A19 Downhill Lane Junction Improvement

Scheme Number: TR010024

7.16 Applicant's Comments on Responses to ExA's Written Questions (ExQ1) and on Additional Information / Submissions Received by Deadline 2

Regulation Number:	Rule 8(1)(c)(ii)
Planning Inspectorate Scheme Reference	TR010024
Application Document Reference	TR010024/APP/7.16
Author:	A19 Project Team, Highways England & Jacobs

FIGURE 8.1

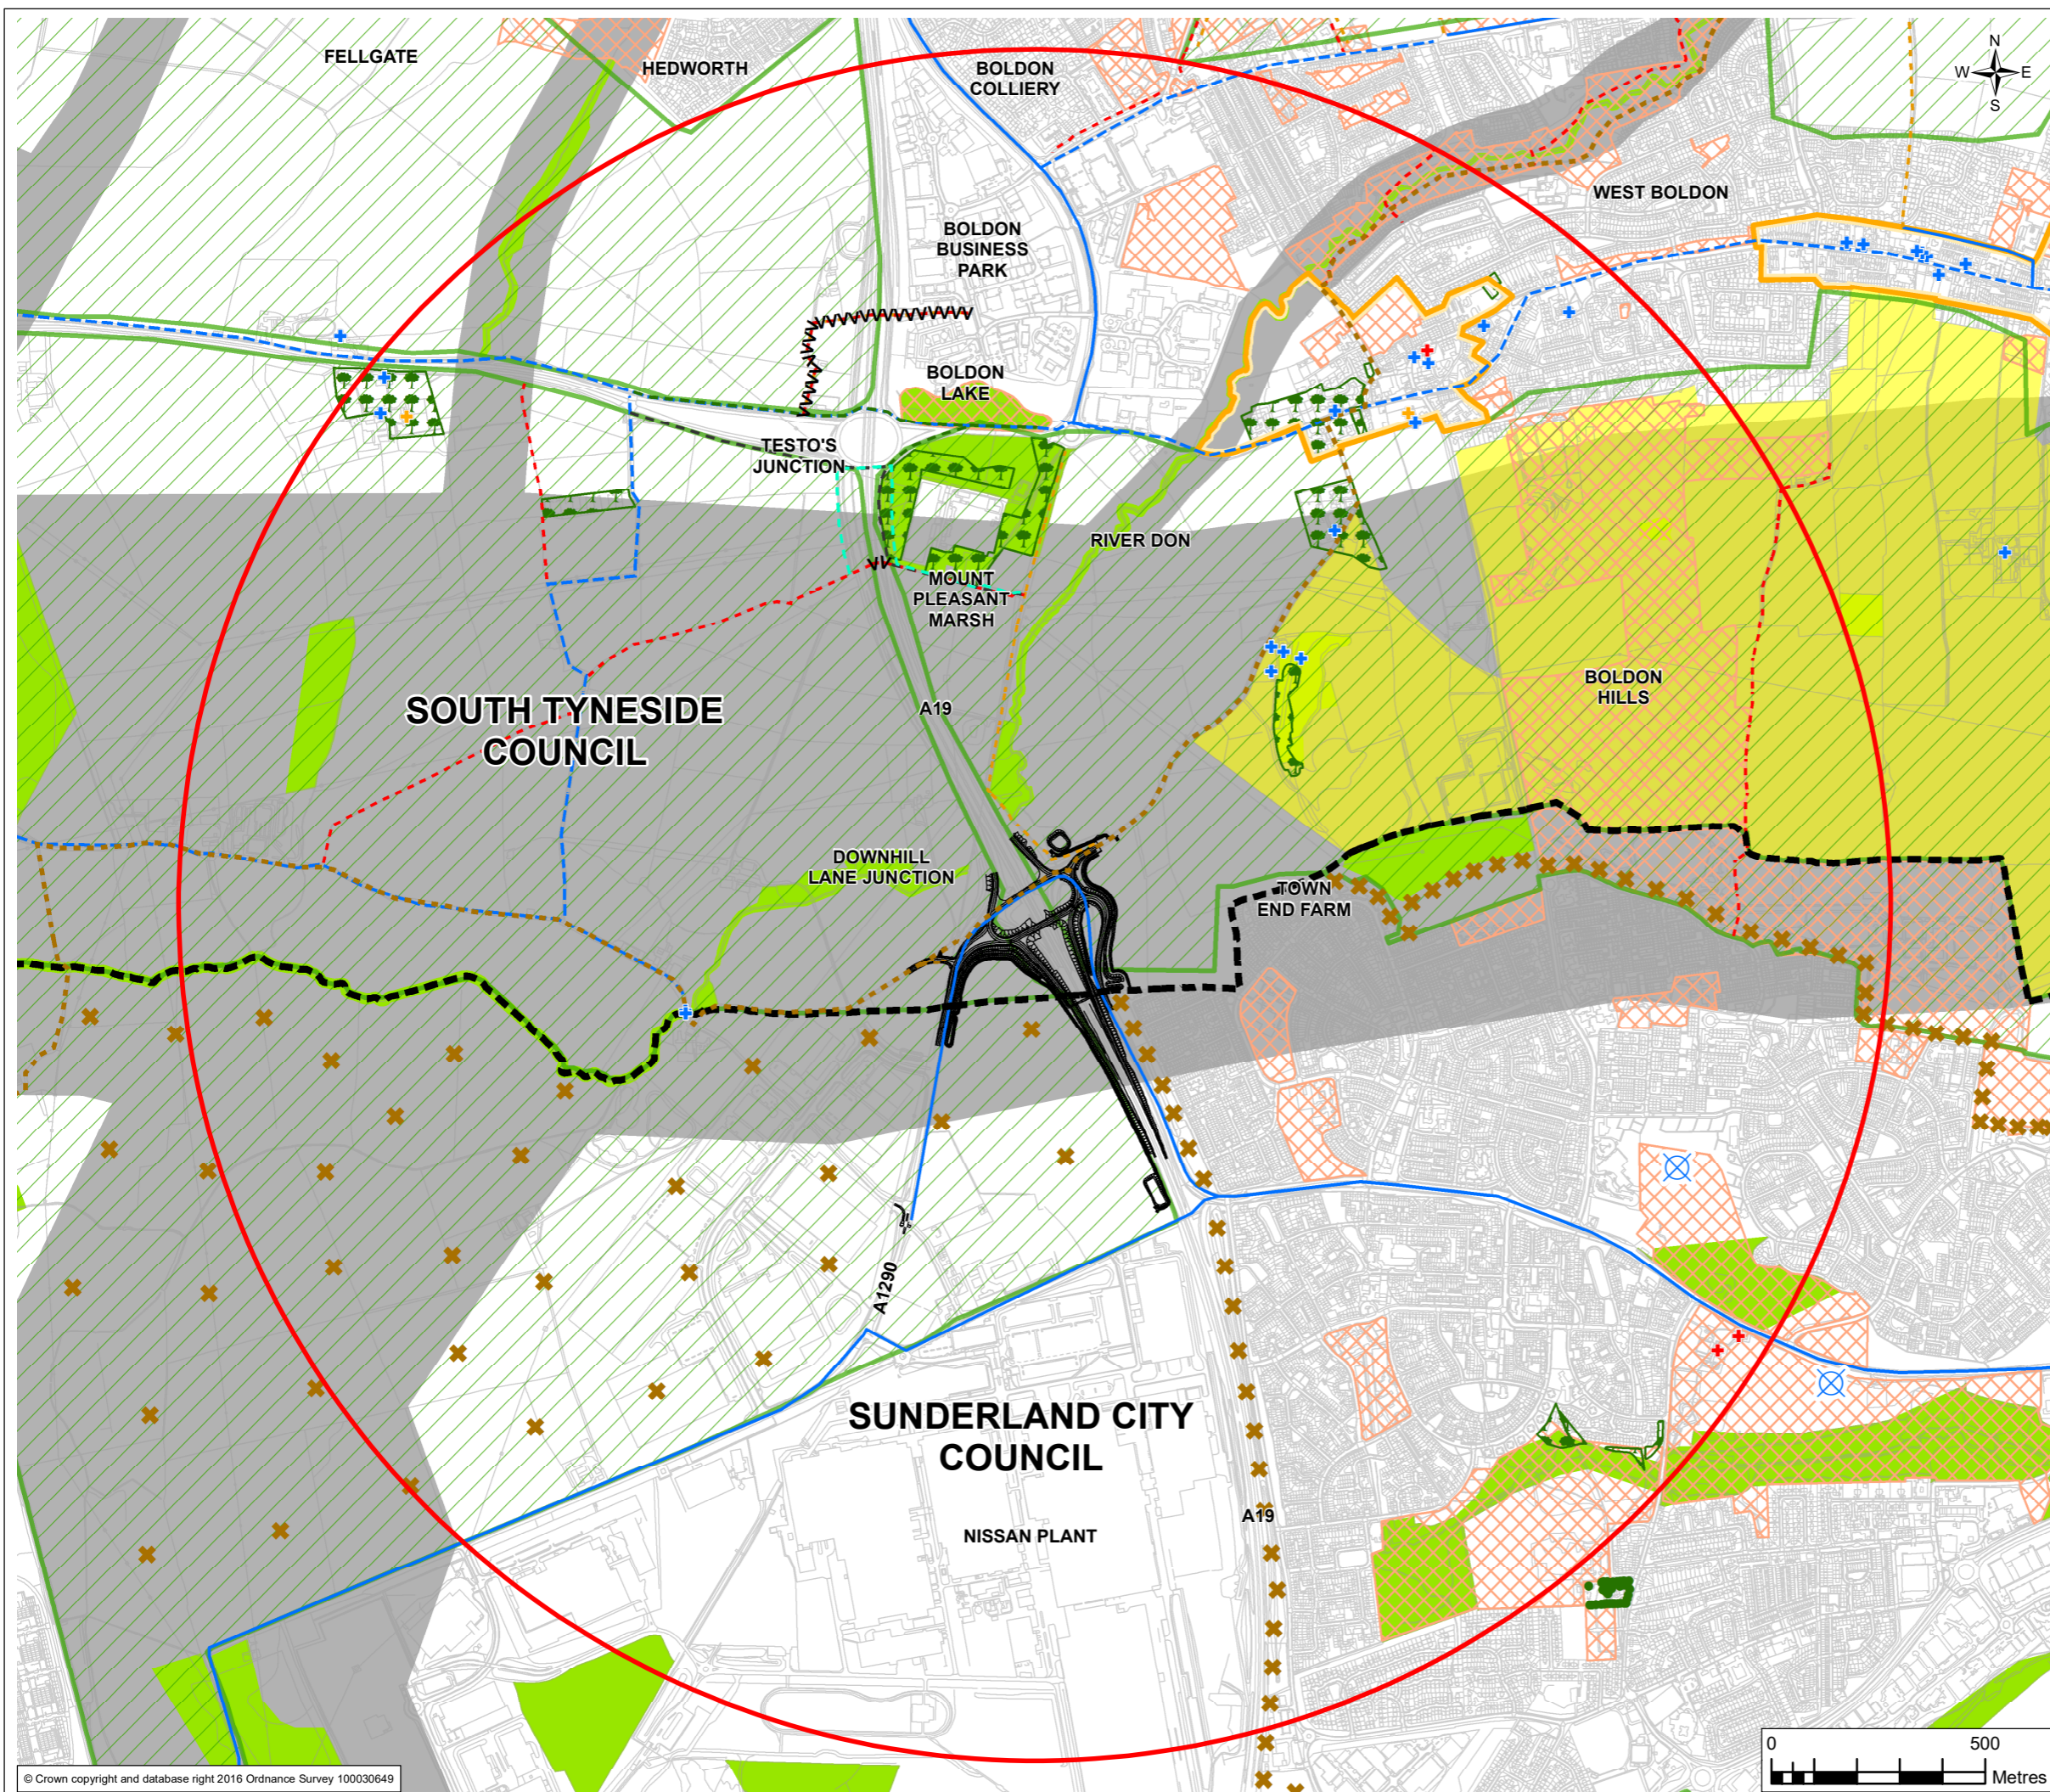
Ref No.	Question:	Response:
	STCs Responses to ExQ1s	
Q1.8.2	STC considers that it might be advantageous for figure 8.1 to be updated and to reflect that Testo's DCO has been consented.	Figure 8.1 incorporates the modified Ordnance Survey background which includes the consented Testo's scheme.
	SCCs Responses to ExQ1s	
Q1.1.1	The works listed (a) to (o) at the end of Schedule 1 appear to be general provisions to cater for any unknown works at this stage. This approach is considered to be reasonable. Any additional works outside the limits of deviation impacting on the Local Authority areas will need to be identified and agreed in advance to ensure any potential impacts are mitigated appropriately.	Noted. The Applicant would note that Article 3(1) of the dDCO (Application Document Reference: TR010024/APP/3.1(4)) only authorises works within the Scheme boundary as shown on the Land Plans and so would not permit Works in Schedule 1 to be completed outside of the limits of deviation.
